ENG-CD19002-R4-CD-redlines.pdf Markup Summary

LORSON RANCH
CREEKSIDE DEVELOPMENT
EAST FORK JIMMY CAMP CREEK
 CHANNEL PLAN AND PROFILE STA 45+00 TO 50+00
 EL PASO COUNTY, COLORADO

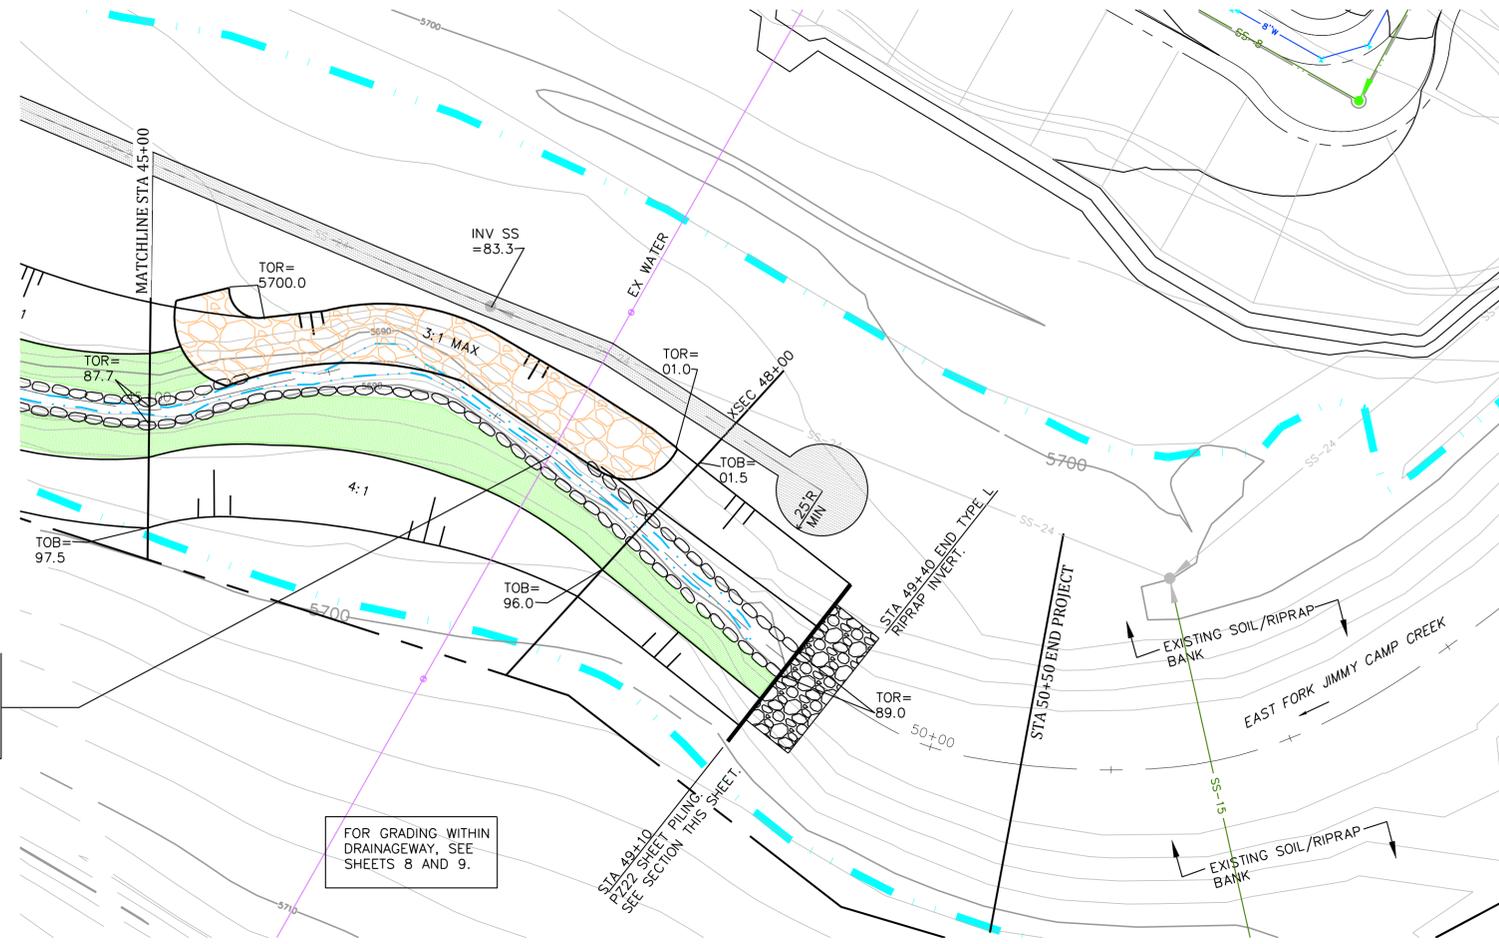
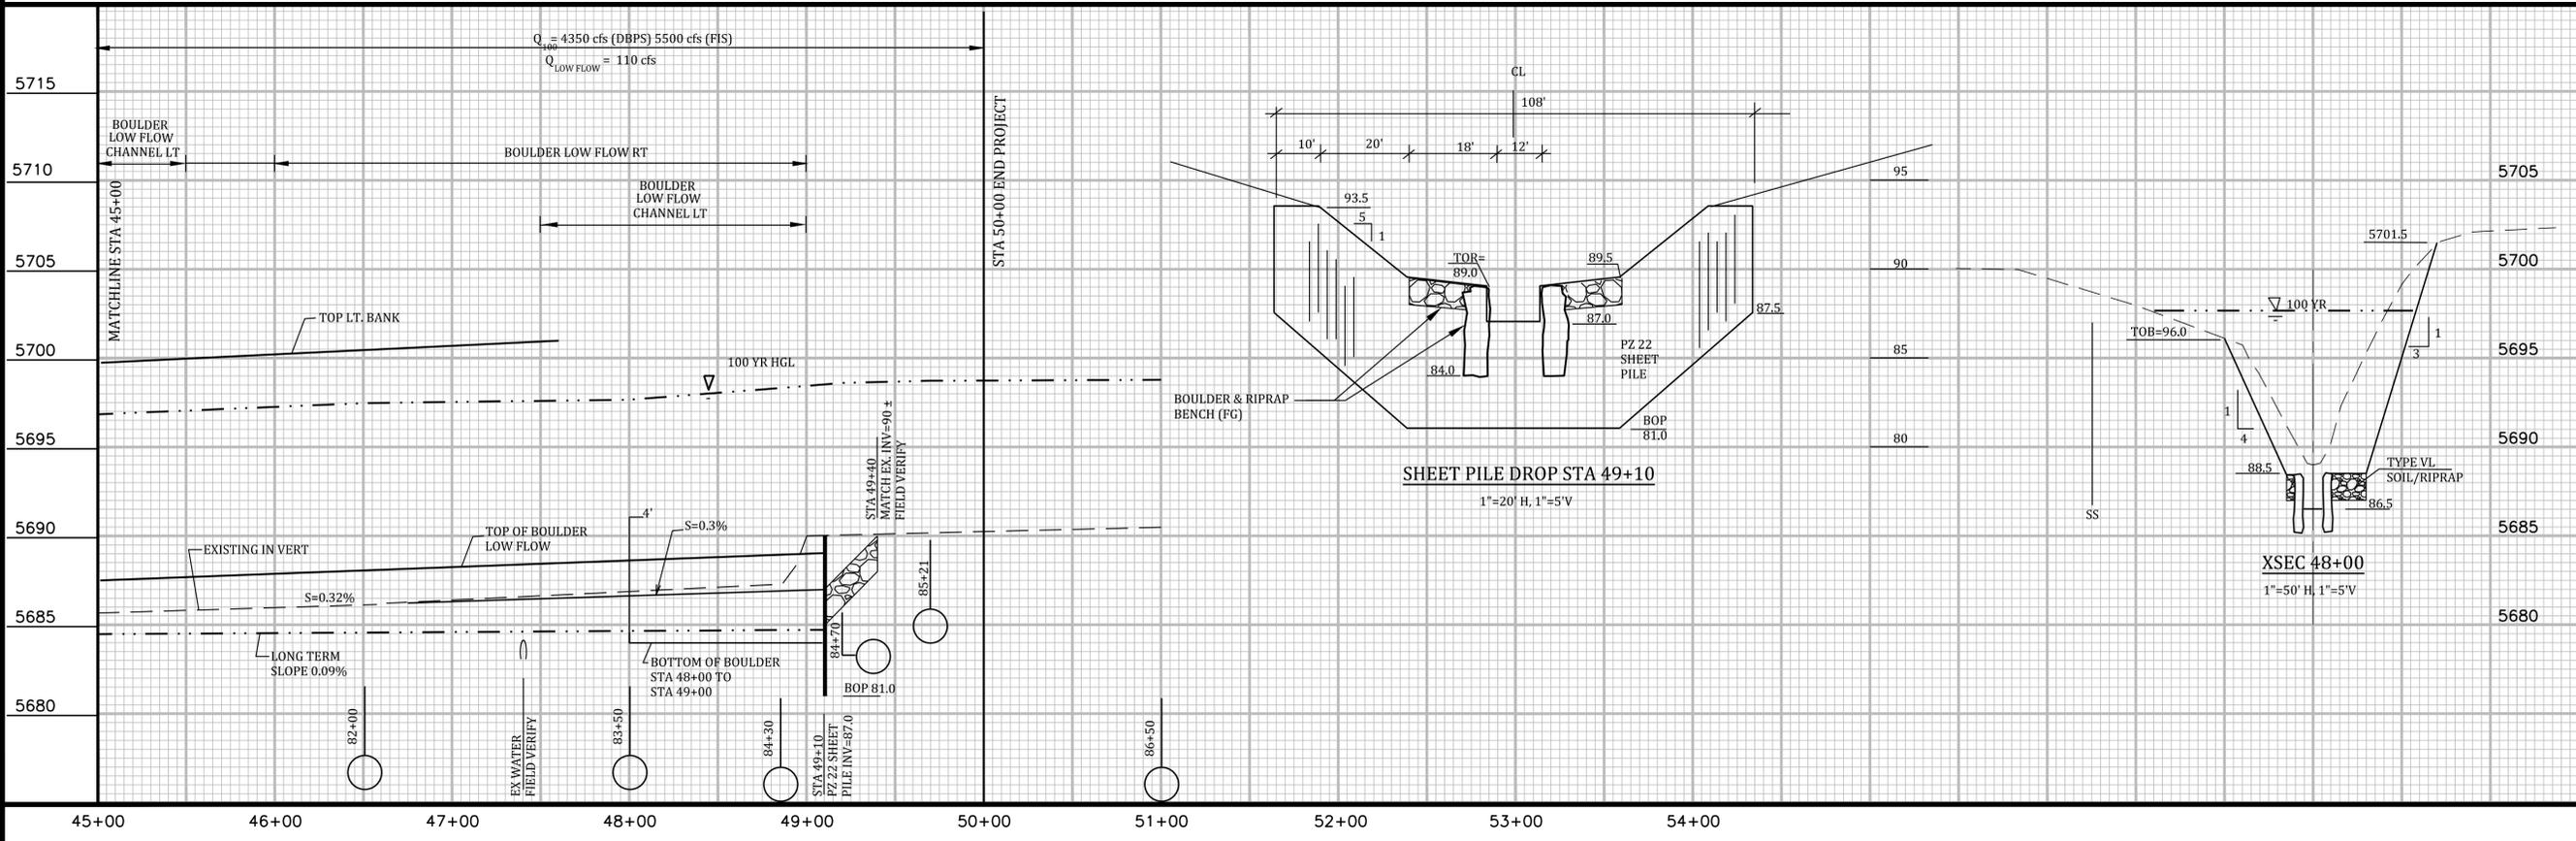
show long term slope

14+88
Unresolved.

Future grade
Unresolved.

45+00

provide details / profiles of pipe and spillway

**LORSON RANCH
CREEKSIDE DEVELOPMENT
EAST FORK JIMMY CAMP CREEK
CHANNEL PLAN AND PROFILE
EL PASO COUNTY, COLORADO**

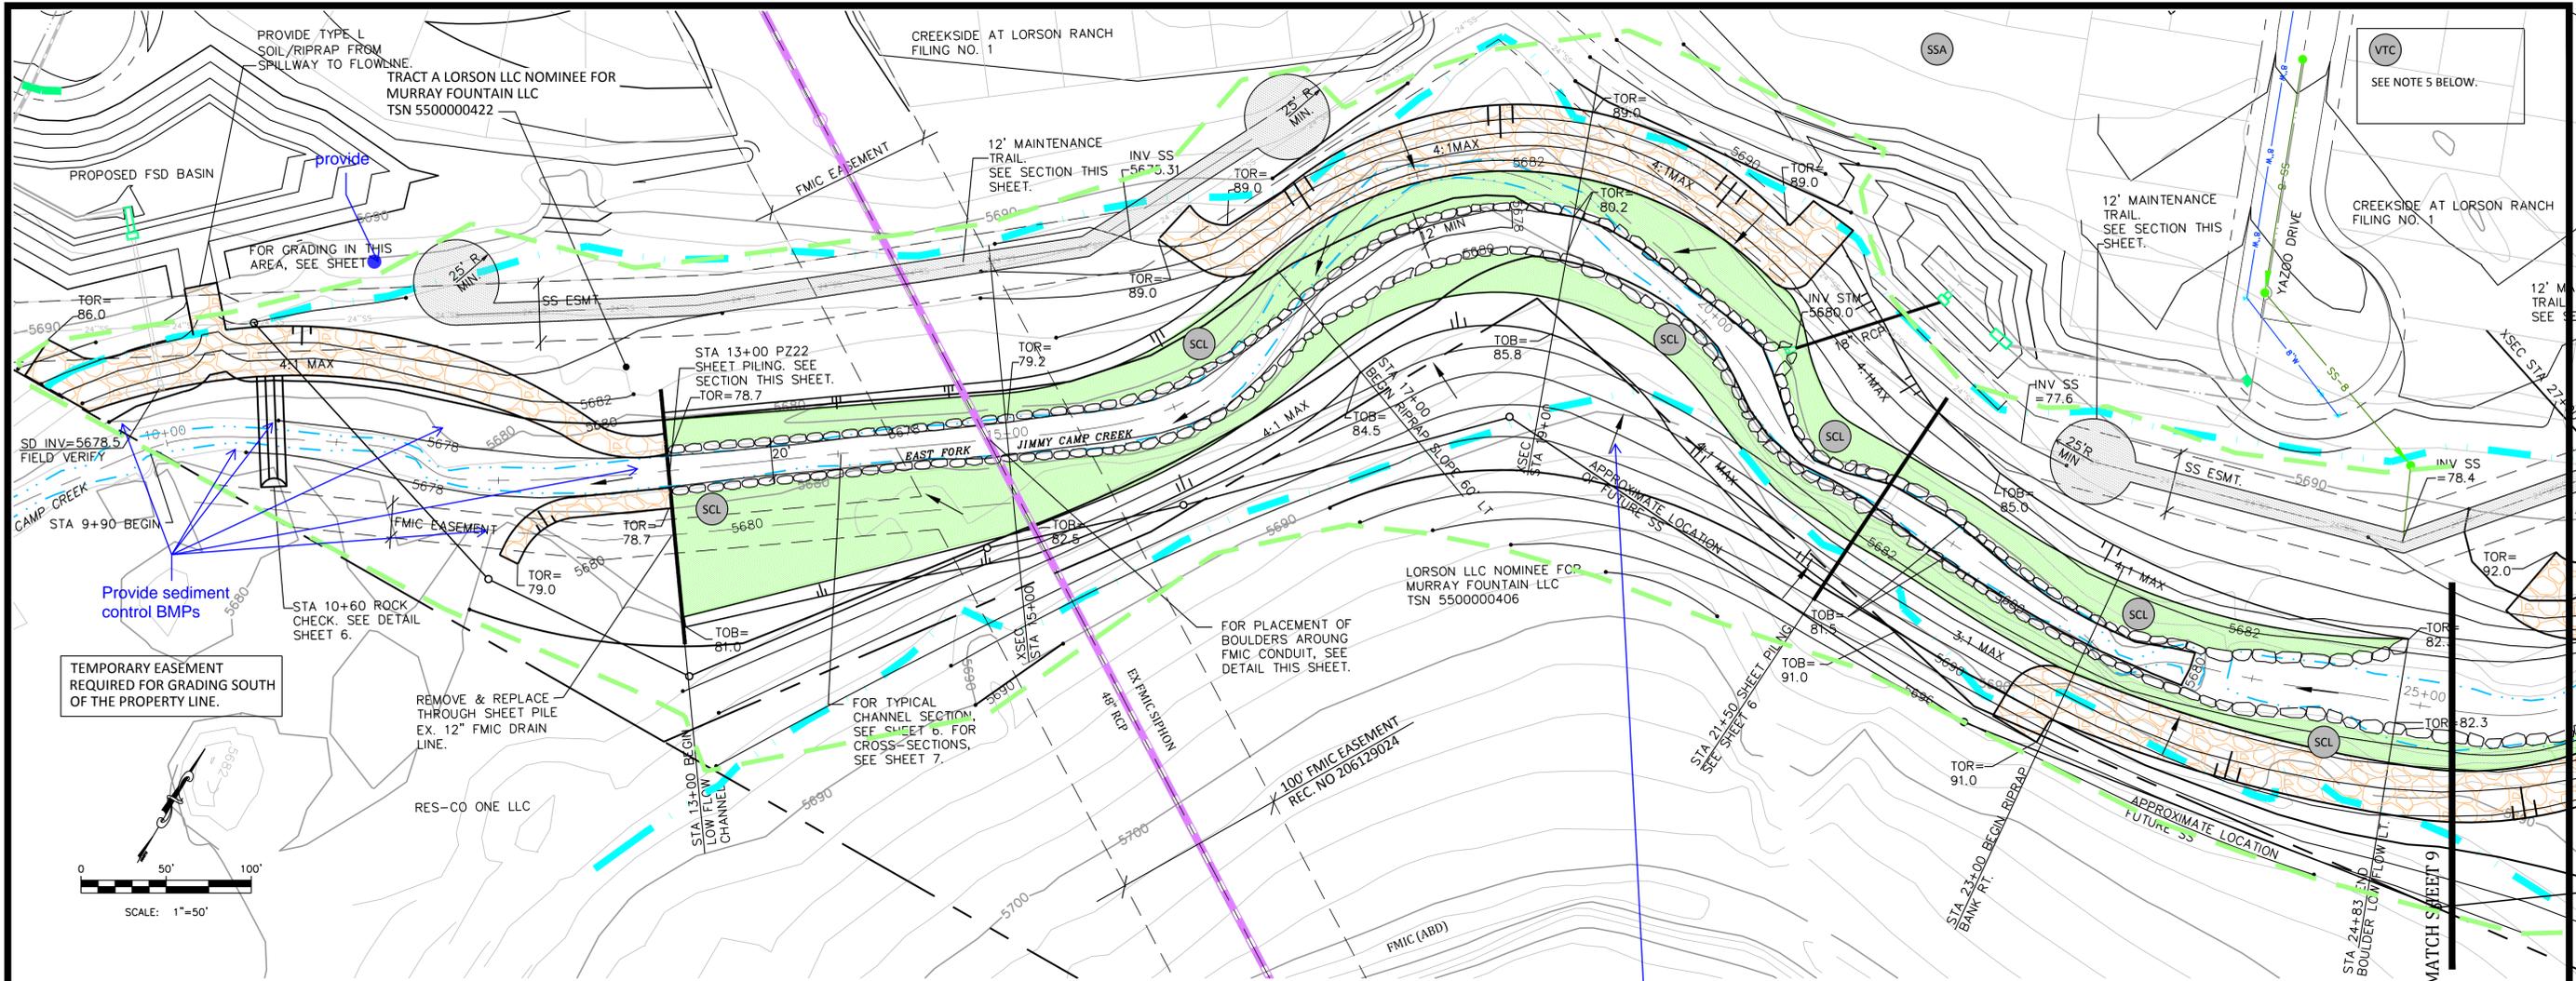
Provide sediment control BMPs

Stabilized Staging Area (SSA) SM-6

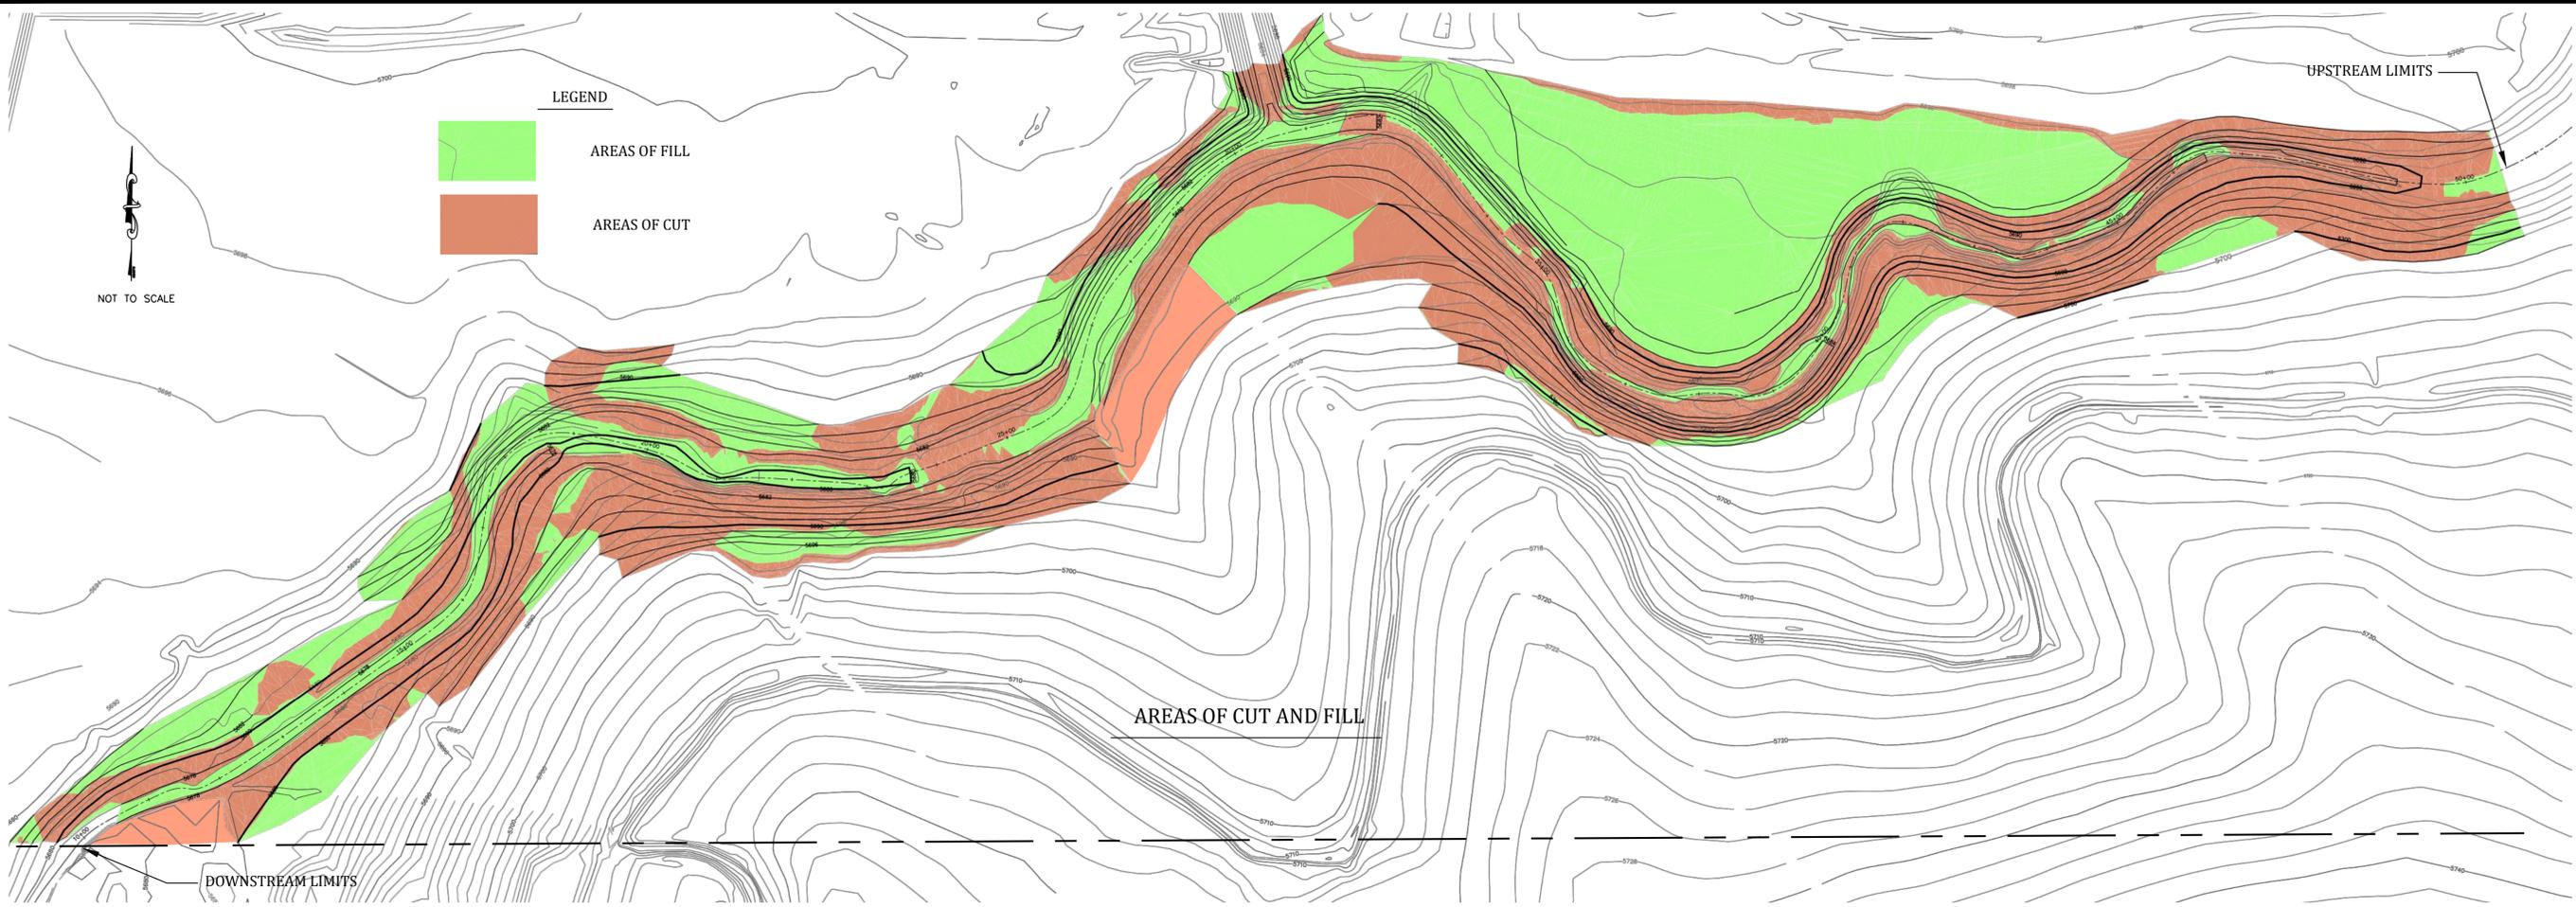
replace with EPC approved VTC detail (DCM Vol. 2)
